WEST SUSSEX COUNTY COUNCIL CONSULTATION

TO:	Arun District Council FAO: Amy Myer
FROM:	WSCC - Highways Authority
DATE:	17 December 2020
LOCATION:	Land East of North End Road and West of Church Lane Nursery Yapton BN18 0GA
SUBJECT:	Y/126/20/DOC Approval if details reserved by condition imposed under ref Y/18/20/PL relating to Condition Nos 6 - Construction & Environmental Management Plan, 9 - mitigation method statement re hedgerows, 10 - wildlife enhancement, 11 - landscaping, 12 - materials & finishes, 13 - screen walls & fences, 14 - Part M of Building Regs 2010, 16 - cycle parking, 18 - energy efficiency, 19 - electric vehicle charging and 20 - external lighting. More information received.
RECOMMENDATION:	No Objection

PROPOSED CONSTRUCTION PLAN
(1:200)

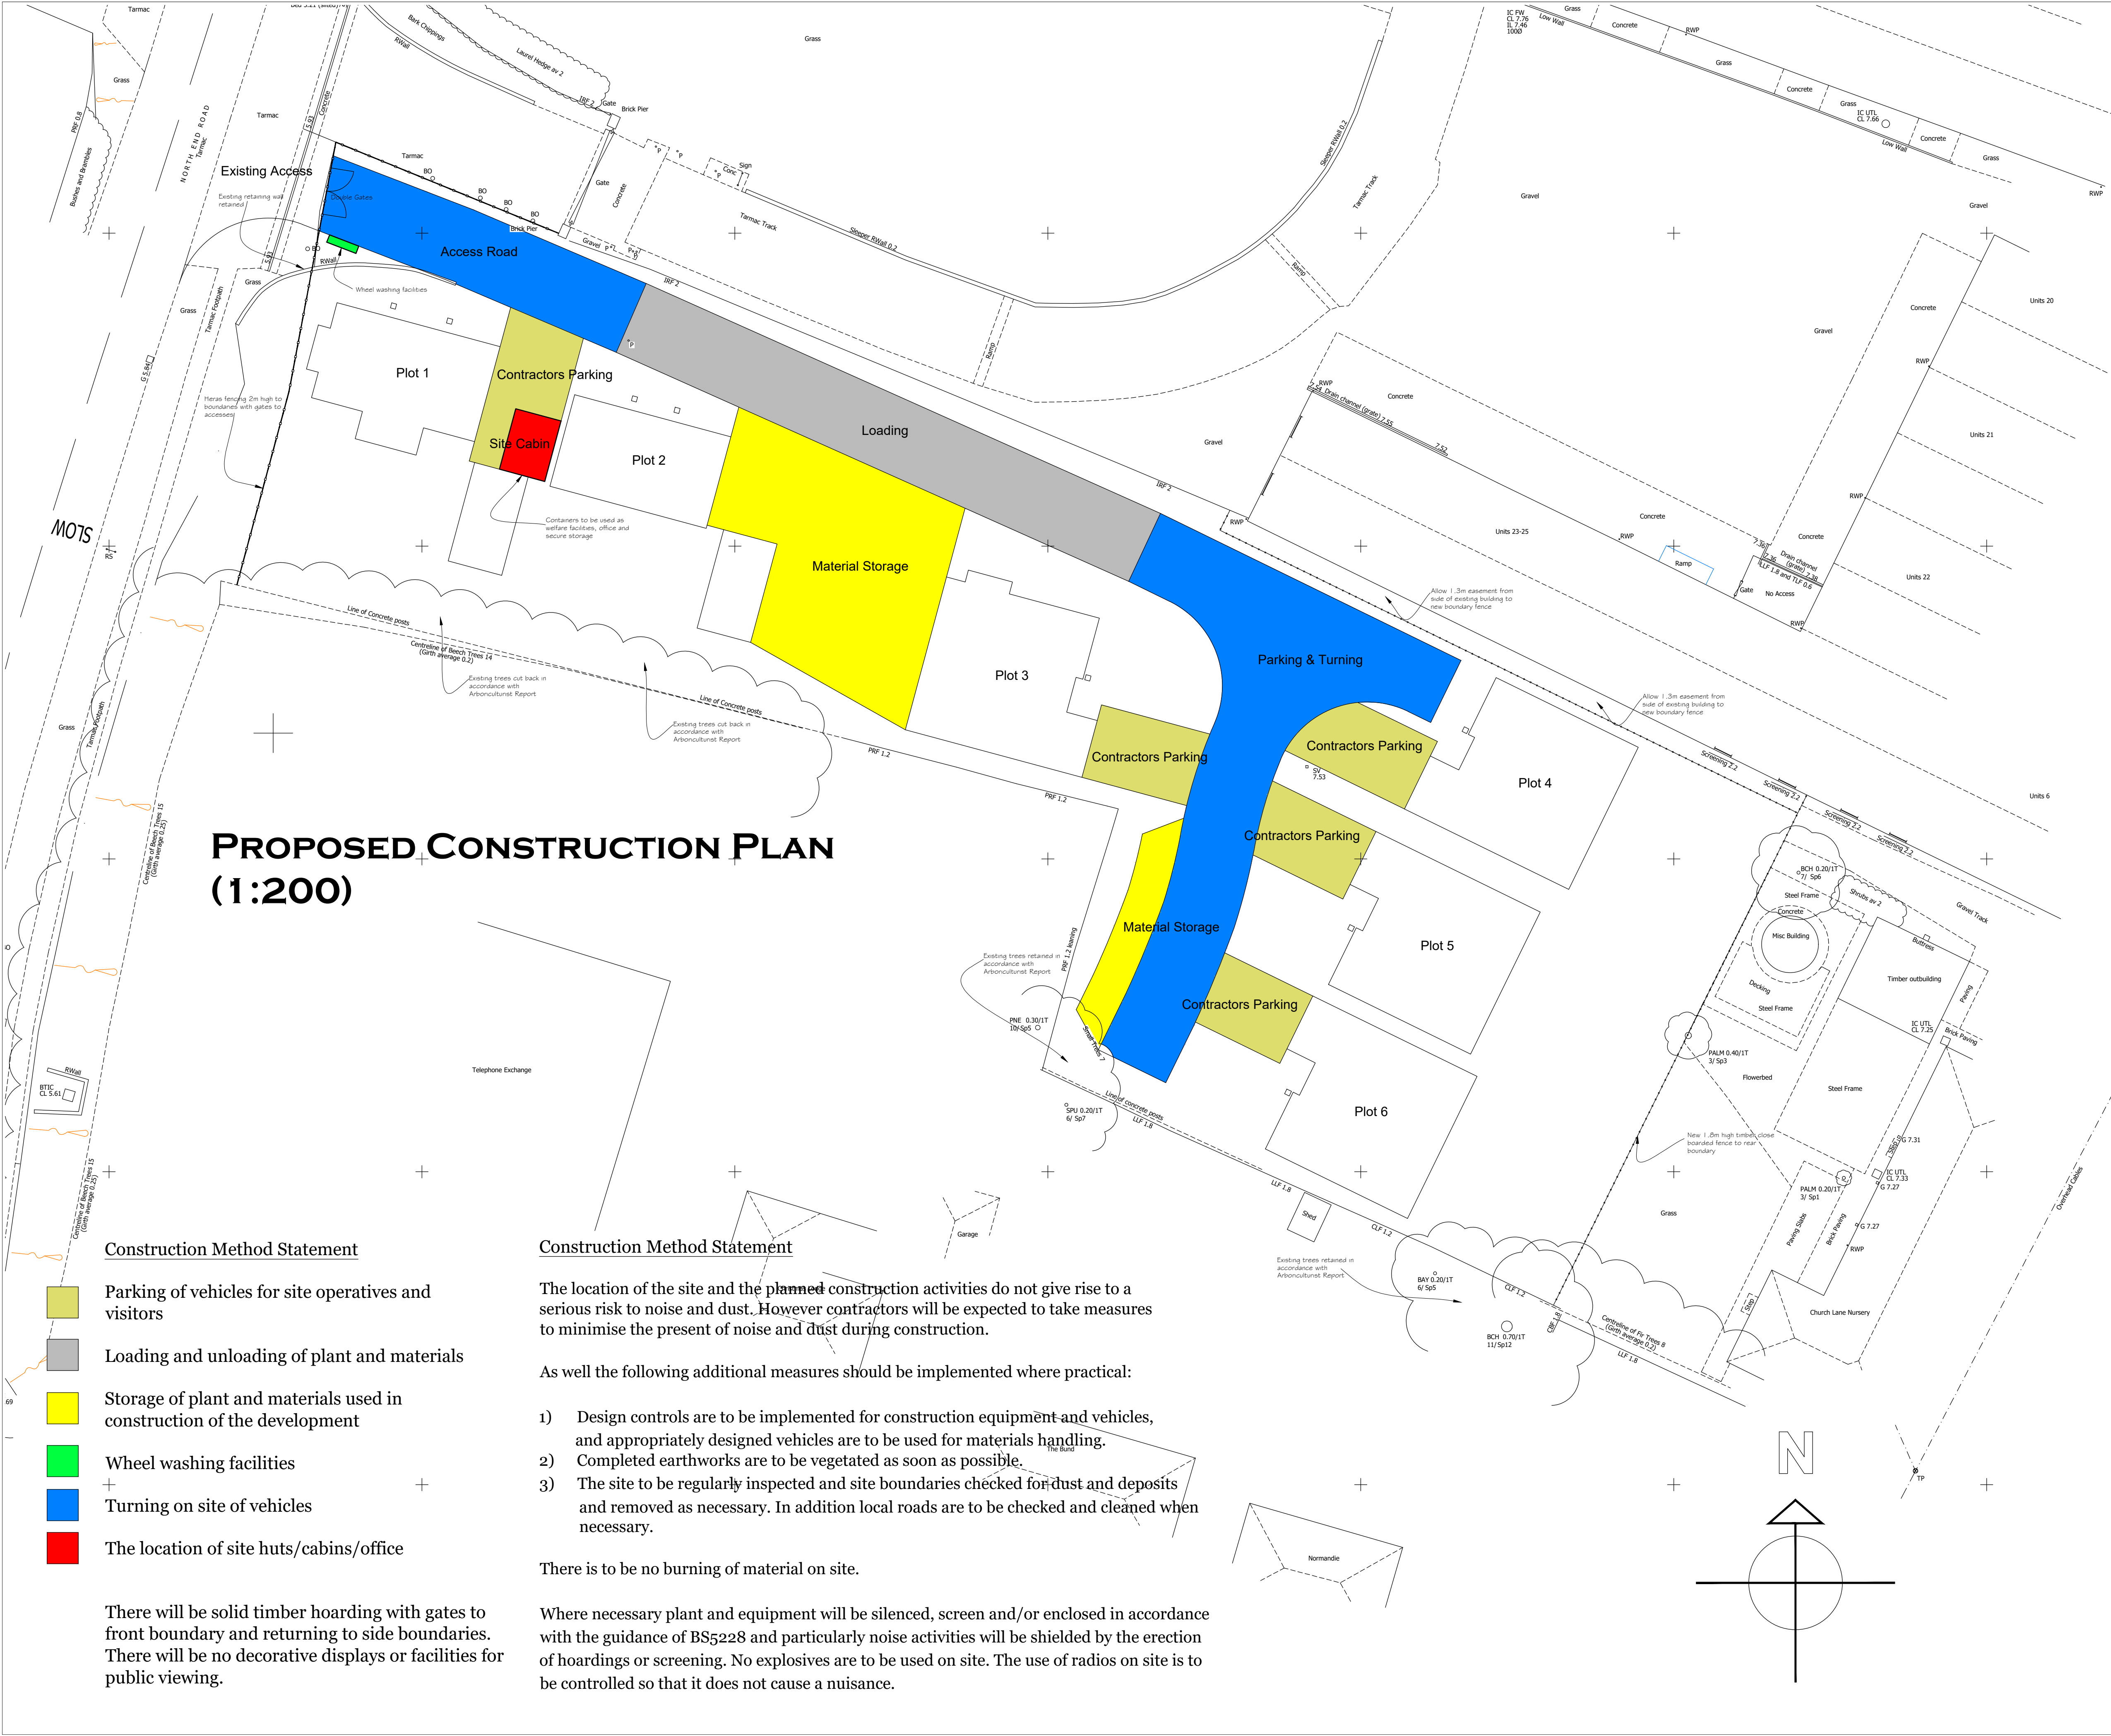
It has now been clarified that the existing main site access will be used and the set-up plan shows this in detail. The plan also shows areas for wheel washing, contractor parking, material storage, loading/unloading and a turning head so that construction vehicles can turn on site and exit to the public highway in a forward gear. All activities will take place clear of the public highway.

The CEMP also states that deliveries will be restricted to 3-4 movements per day. Considering the scale of the development this is not anticipated to result in a road network capacity issue on the nearby public highway network.

The plans and details pertaining to condition 6 are acceptable.
